# Mallard Pass

### Environmental Statement Volume 2 Appendix 7.3: Ecology and Biodiversity - Consultation Summary

Document Ref: EN010127/APP/6.2

### **Appendix 7.3: Consultation Record and Responses Relevant to Ecology and Biodiversity**

Drawing file: EN010127 / EN010127-000209-Figure 06.11_Green Infrastructure Strategy Plan.pdf

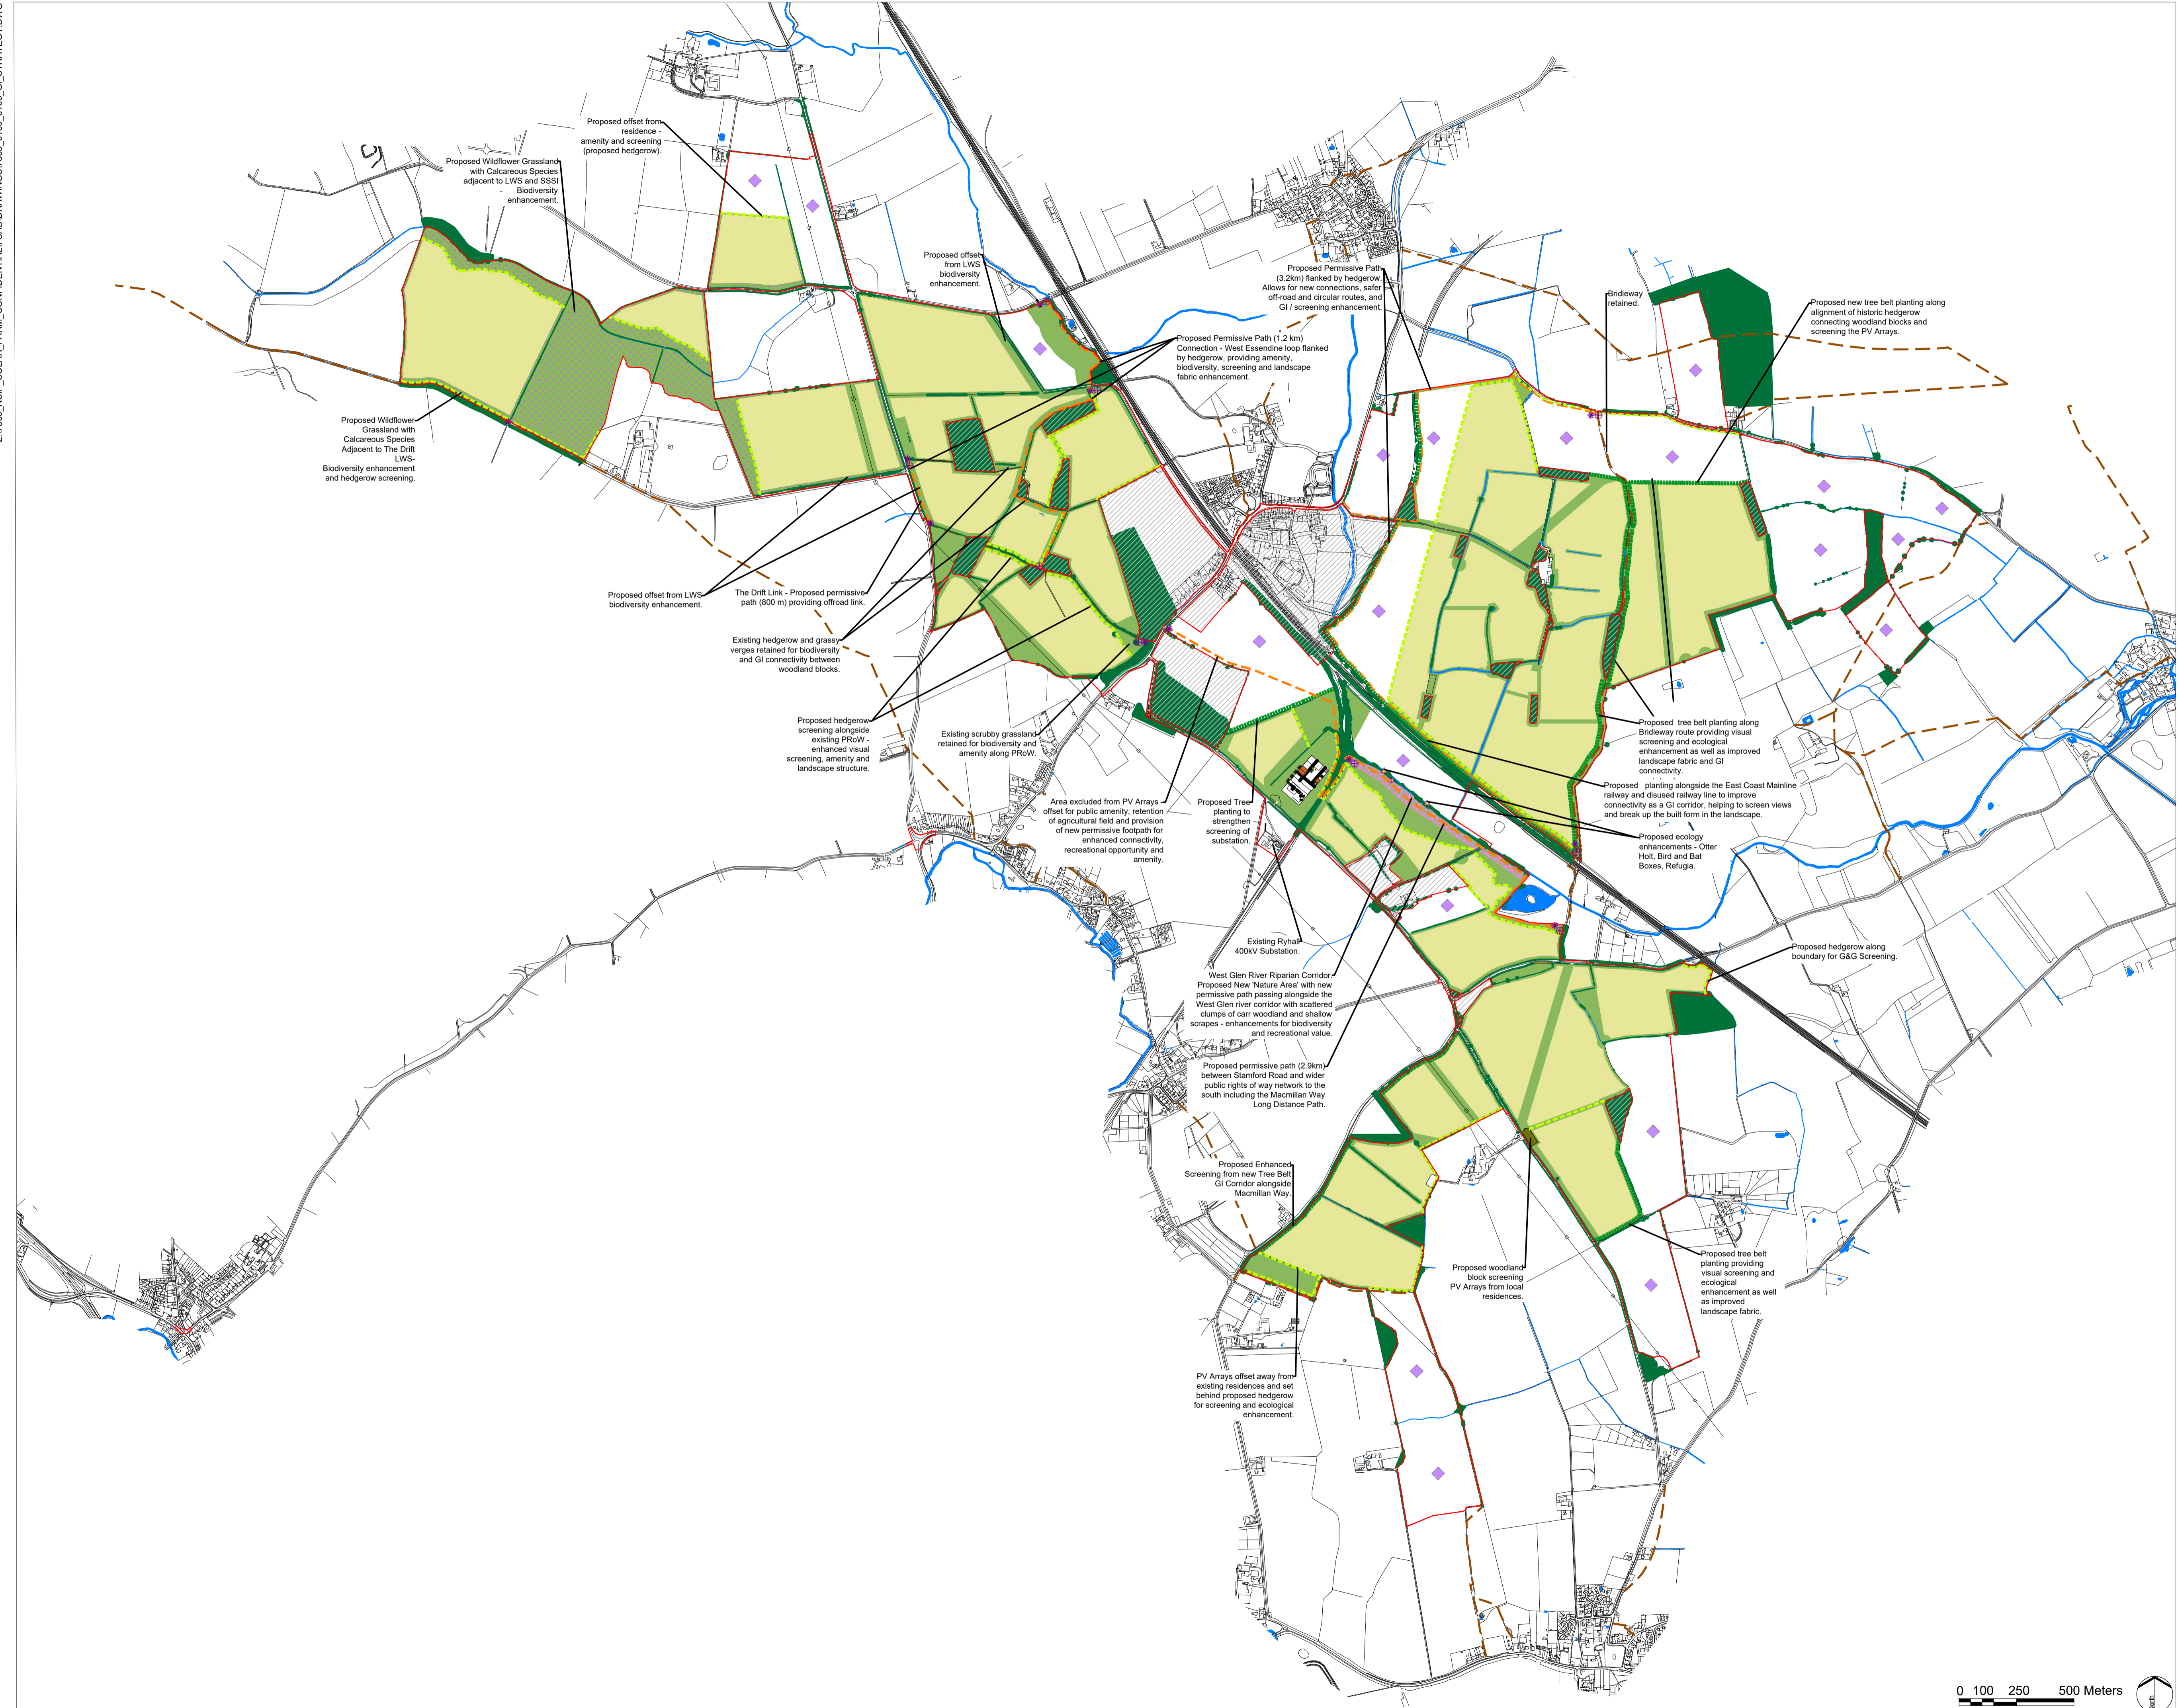
NE	<p>We would also particularly need details on proposed habitat connectivity to surrounding habitats which would contribute to the wider Nature Recovery Network and if included in an</p>	<p><b>Figure 6.11: Green Infrastructure Strategy Plan</b> includes new woodland belts, hedgerows and grassland habitats connecting similar habitats within the Order limits and adjacent to it.</p>

Stakeholder / Consultee	Response received	Response
	<p>arable rotation with additional measures to support skylarks. We welcome the production of the Green Infrastructure Strategy (Ref: Figure 6.10) and support the general proposals it makes, which aim to improve the quality and connectivity of habitats at a landscape level across the Order limits, and mitigation and enhancement area, as well as performing important screening and assimilatory functions to respond to and enhance the local landscape fabric.</p> <p>The minimum offsets/buffers from the solar arrays or security, as set out in Table 5.13, will be incorporated within the design of the proposed development, with the exception of where access tracks, security fencing and/or cable routes are required to cross an existing feature.</p> <p>These offsets/buffers have been established based on best practice and guidance and will be used to deliver additional planting of diverse habitats to either increase habitat connectivity and structural diversity through combinations of hedgerow, scrub, grass / wildflower planting.</p> <p>The buffers/offsets are a minimum and for example may be increased to deliver further mitigation or enhancements and/or respond to root protection areas where required.</p> <p>The existing Public Rights of Way (ProW) that cross the Solar PV Site and Ecological Mitigation and Enhancement</p>	<p>Access to all existing PRoW will be retained during the construction phase, with a limited number of temporary PRoW diversions to allow the construction of access tracks where they cross PRoW. The PRoW will be managed throughout the construction phase to ensure that they can continue to be used safely as set out in the <b>oCEMP</b>.</p>
